From: Sue Howell
Sent: 01 November 2018 12:39
To: Planning.Responses
Cc: Simon Davis
Subject: RE: Planning Consultation on P/95/18/DOC

Site Address: The Coop The Parade Pagham PO21 4TW

Description of Works: Application for discharge of conditions imposed on planning reference P/4/18/PL relating to condition 6 - DPC & Landscaping

CLD/605.1/18

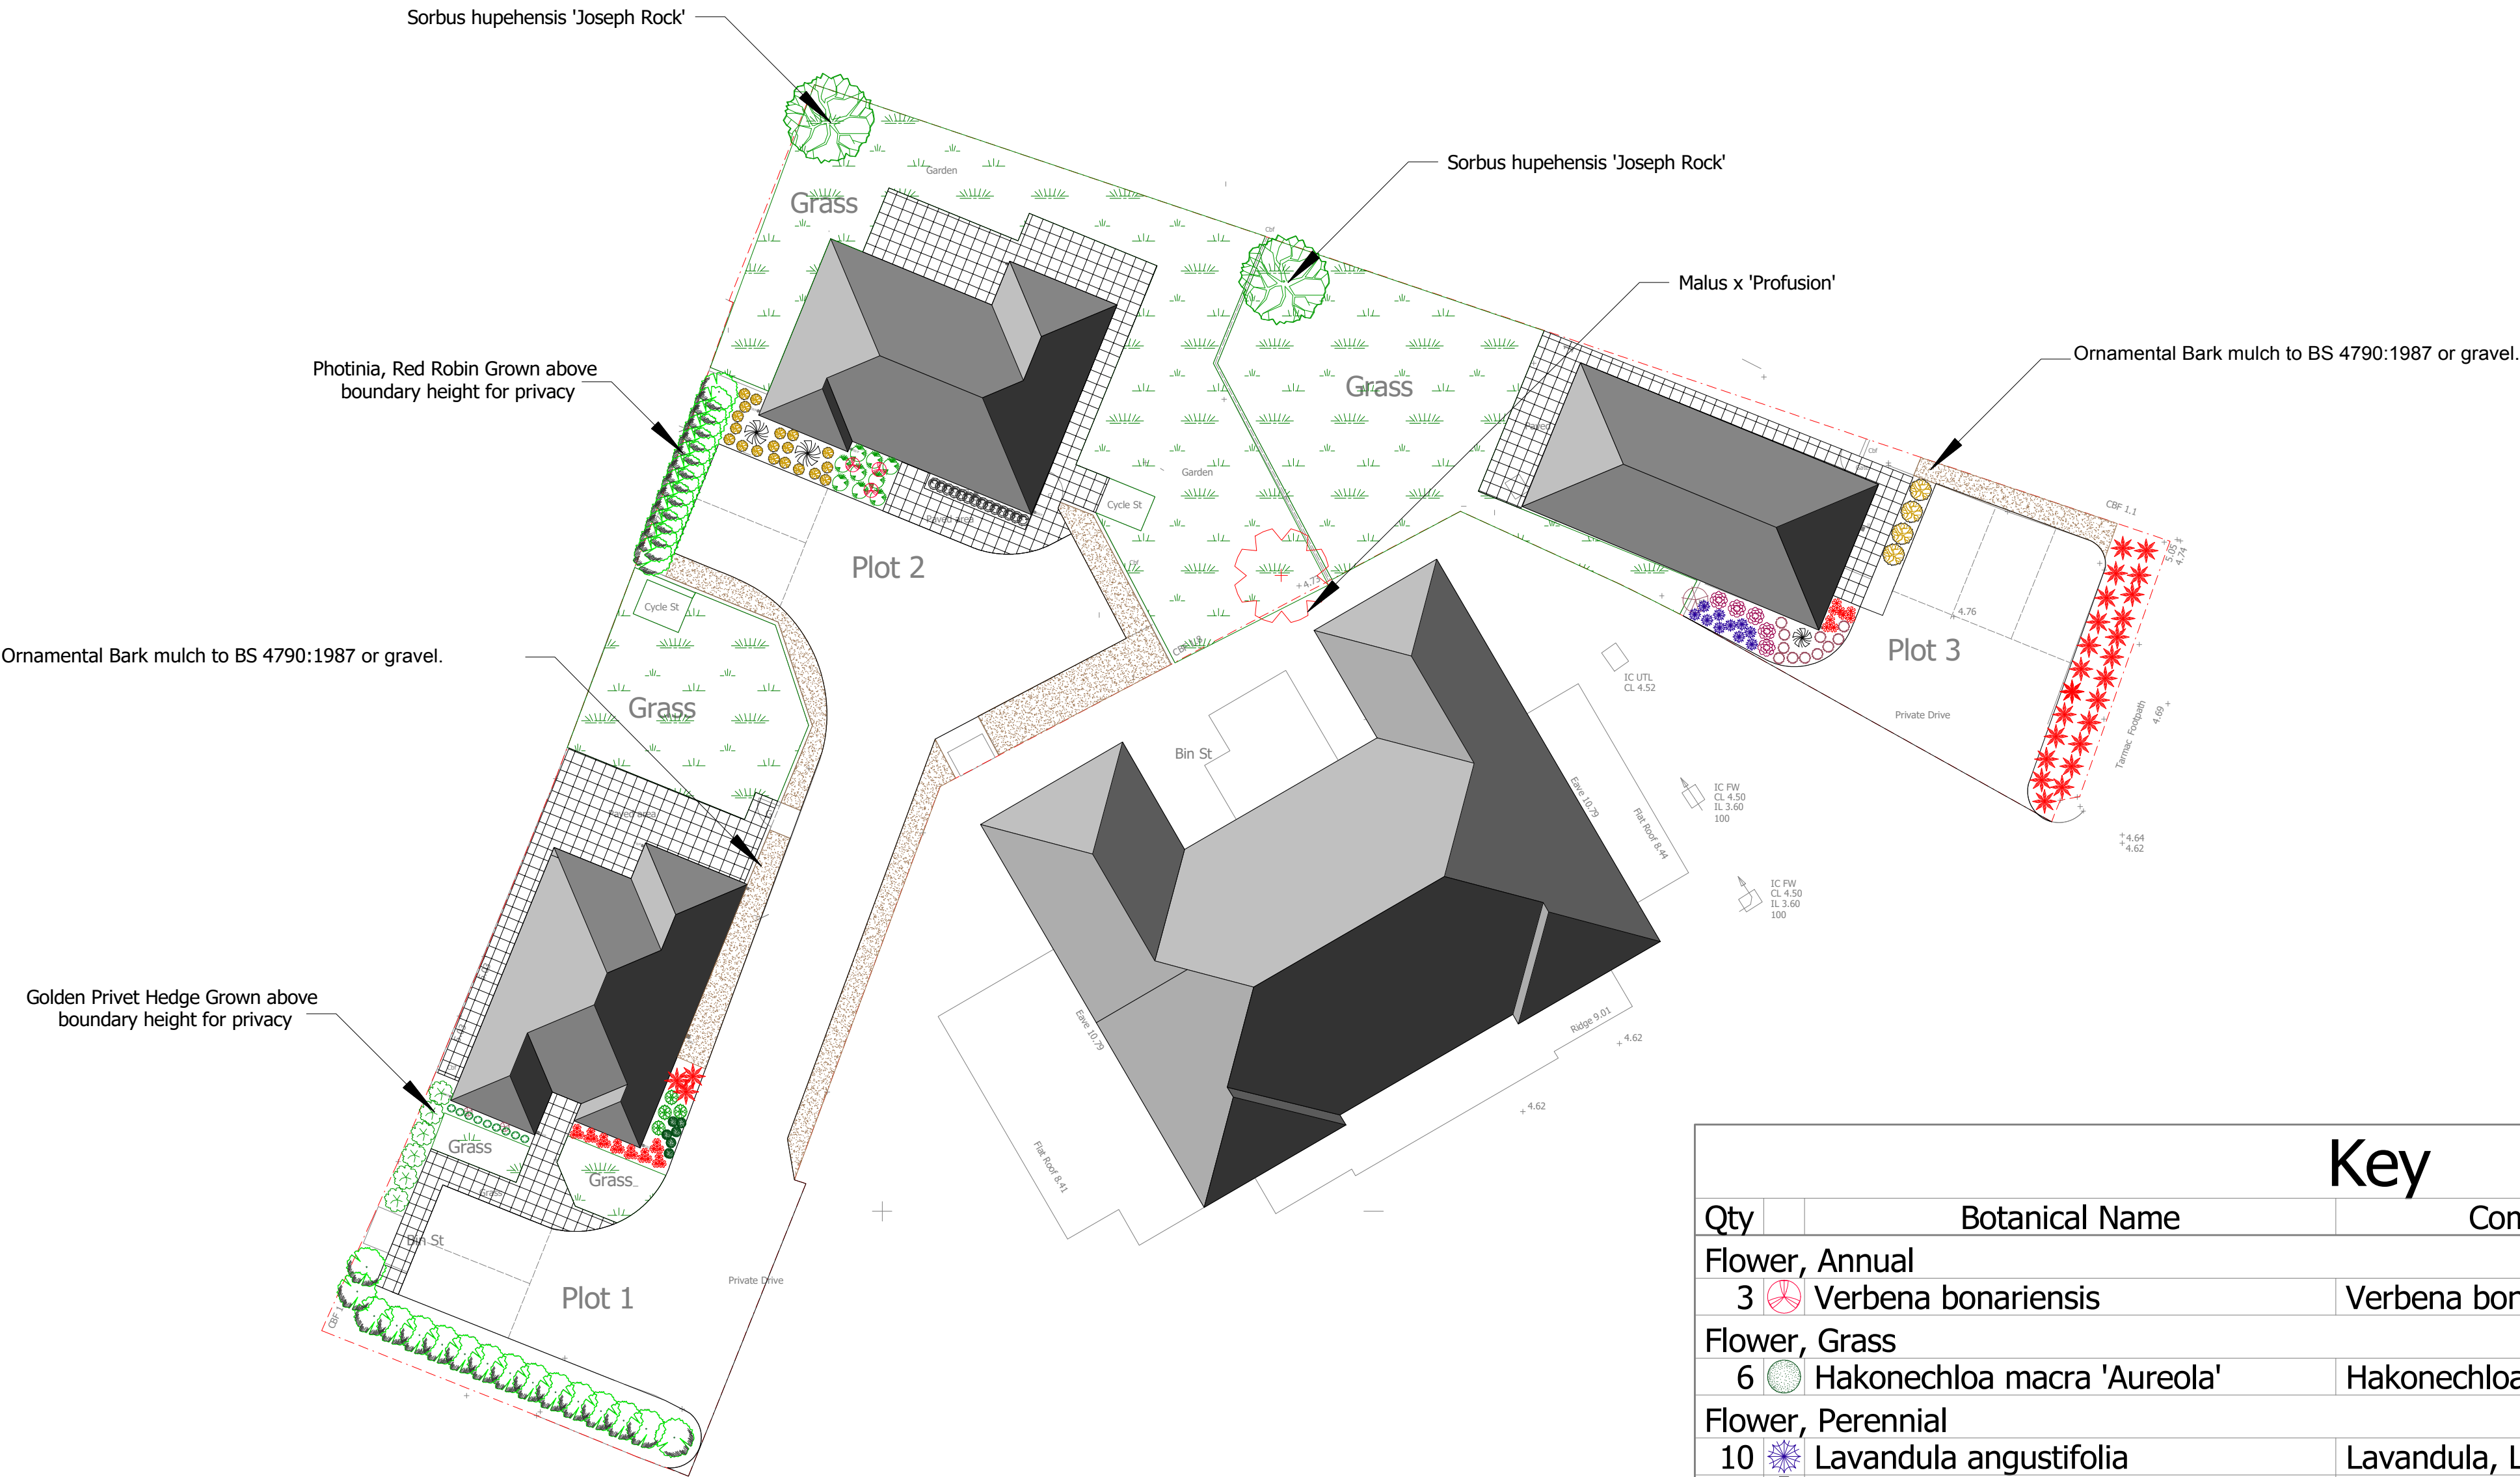
Further to submission of landscape proposals contained in landscape plan CLD/605.1/8. I confirm that the details submitted does show an appropriate landscape scheme, with trees and shrubs in plan form indicating species choice, planting densities and size at time of planting.

From the details submitted I would recommend the discharge of Condition 6 landscaping on this application P/95/18/DOC imposed under planning reference P/4/18/PL.
